DECISION DELEGATED TO DEVELOPMENT MANAGER

Application No: H16-0154-19 **Applicant:** Mr Oliver Sneath

Proposal: Removal of disused painted stone fireplace, removal and bricking up of kitchen serving hatch and dismantling of wood and glass entrance way

Location: The Sessions House Sheep Market Spalding

Example of existing doorway with external light

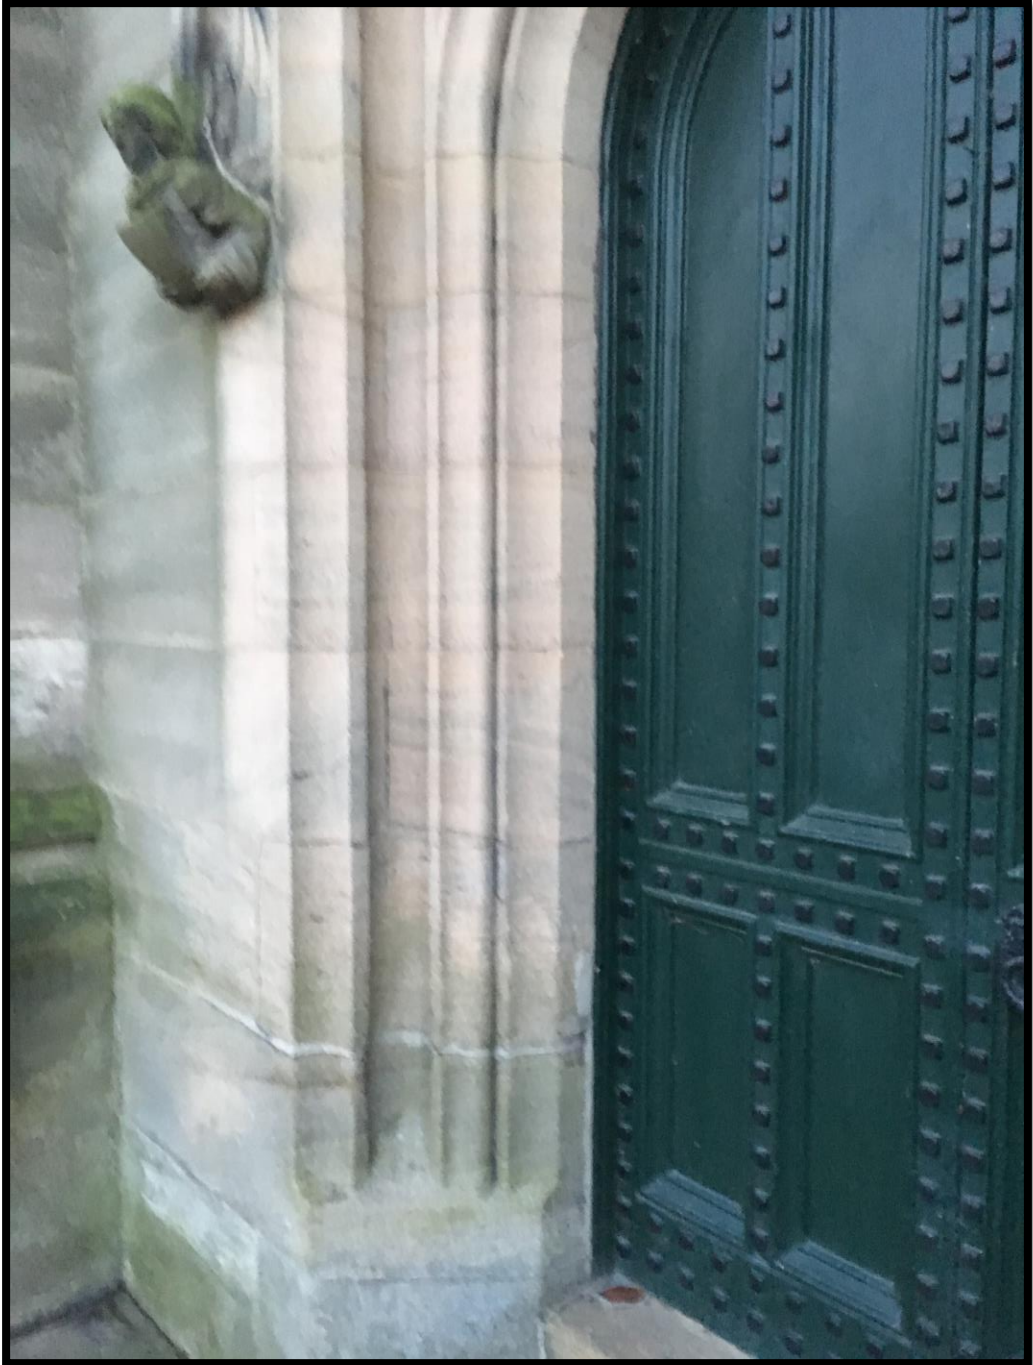
- comfortable with the submission, however we do need a plan showing where the existing and new doorbell are/will go.
- There is no information on the age or significance of the fireplace or justification for removing it. It looks original, and unless there is a strong justification, we would be concerned to see it removed.
- Removing the later glass screen and blocking up the hatch would obviously be improvements!

"Please see attached plan showing the doorbell positioning we have planned.
